CONSULTATION UNDER TOWN AND COUNTRY PLANNING ACT 1990

Application Number	PL/2023/00928/PPFL & PL/2023/00929/LBC
Address	Beeches Restaurant Marsh Lane, Hampton in Arden, Solihull.
Proposal	Retrospective consent for erection of a replacement extraction system
Case Officer	Ian Hiscock

Date comments sent	06 July 2023
Name of consultee department	CLAUDE Historic Environment
Consultation response author	Jon Beesley

Scale	1:25	Paper Size	A1
Date	01.03.23	Drawn By	LM
Drawing No	EQ1408-1027-05		Rev C

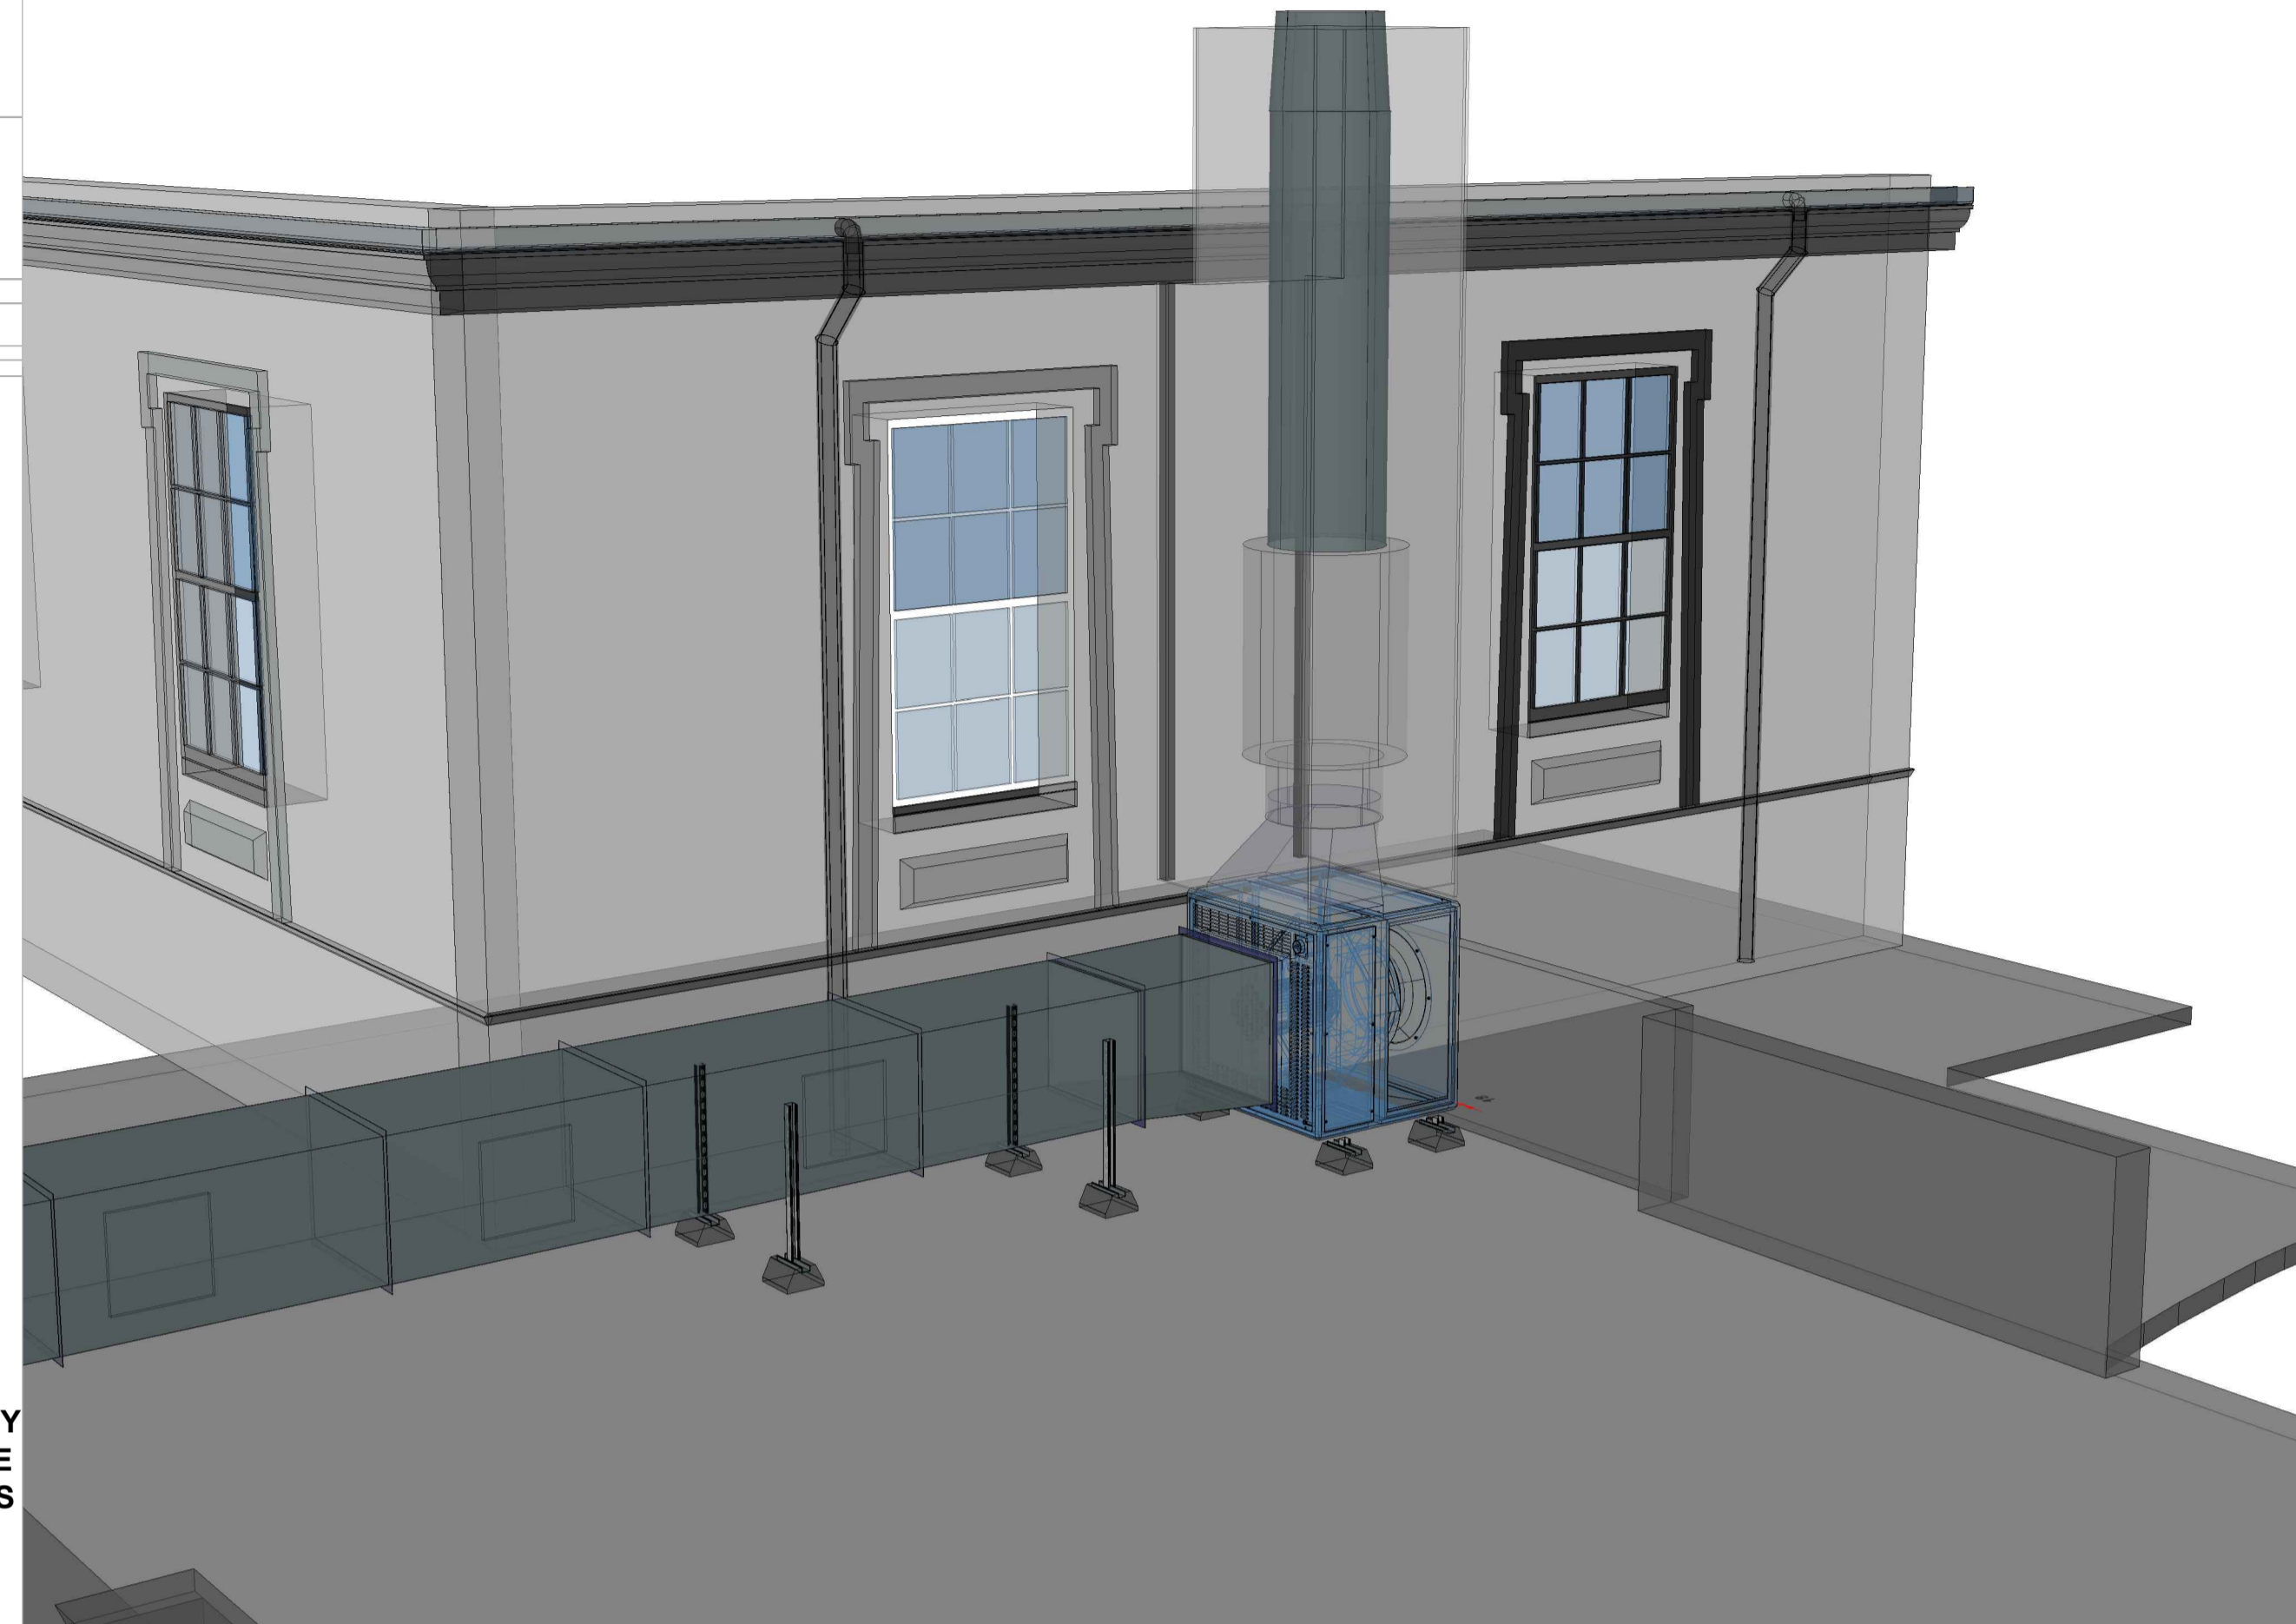
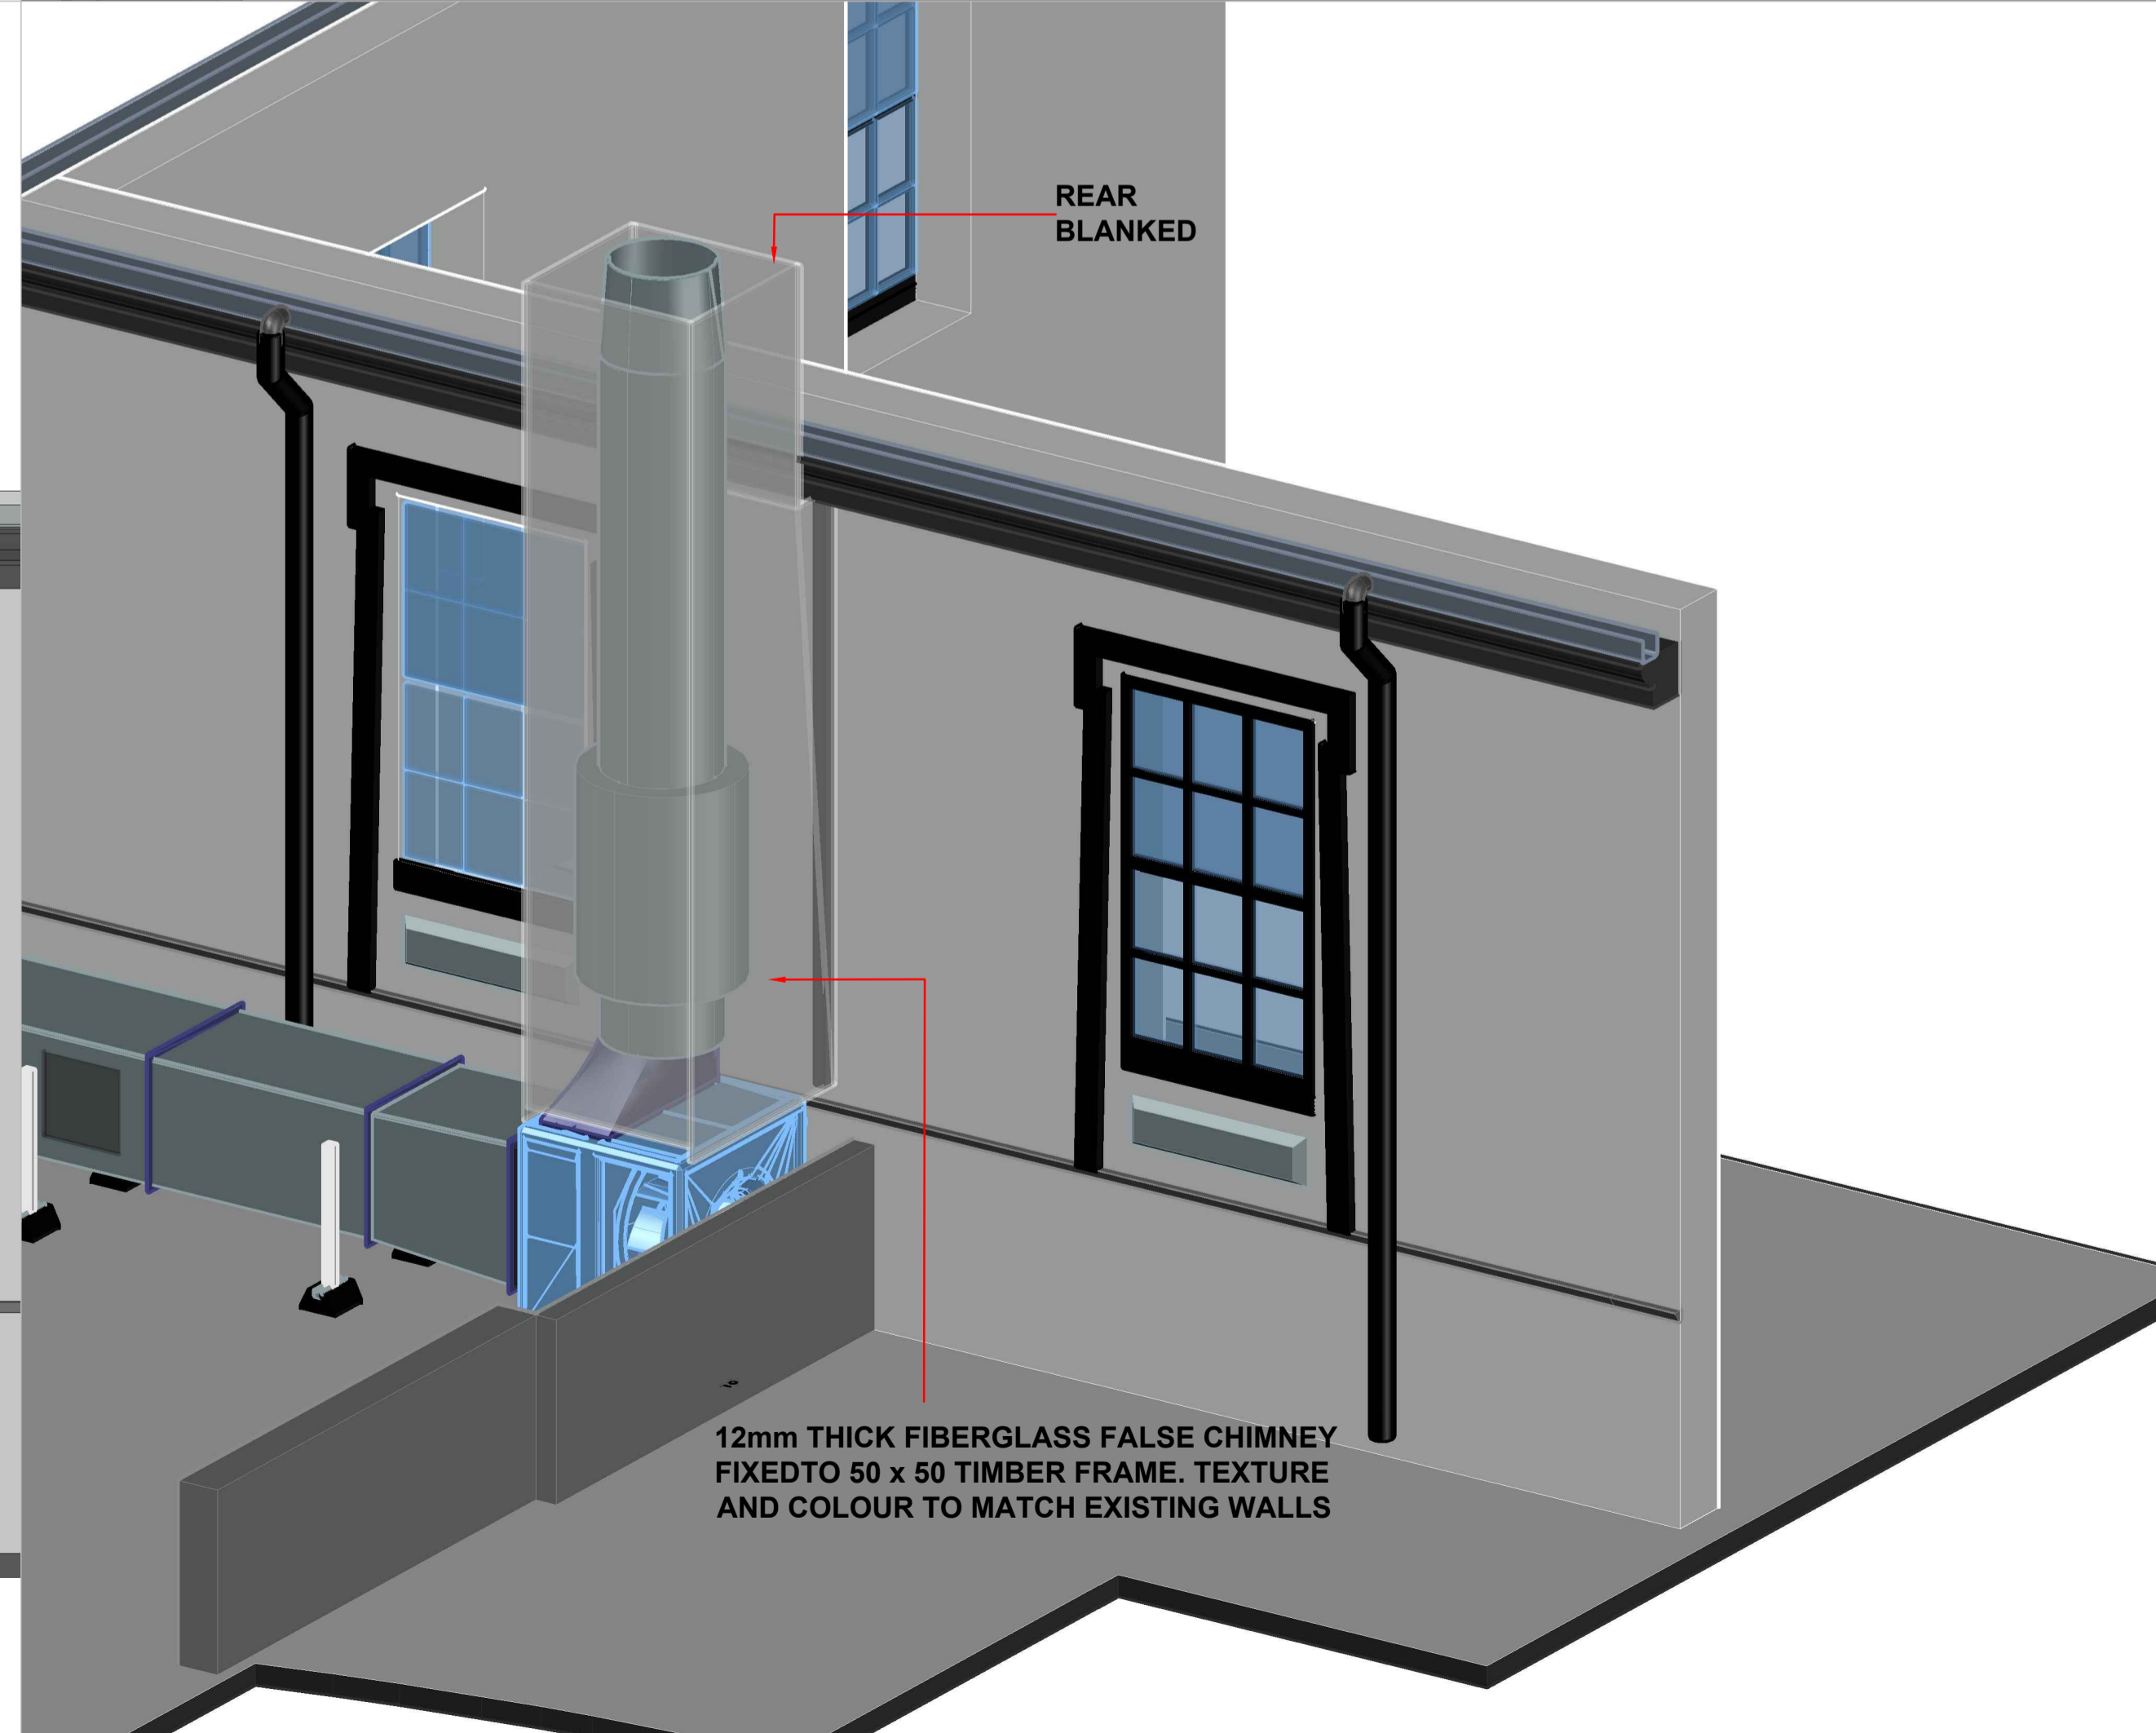
Concern was raised that the proposed cladding would partially obscure the window surround, which would harm the significance of the listed building. (*Ref: Heritage comments PL/2022/02174/PPFL & PL/2022/02175/LBC dated 9 Dec 2022.*) Further information on the installation was requested to allow an assessment of the potential impact on significance of the heritage assets. The issue has been addressed; and the proposed cladding should not obscure the window surround.
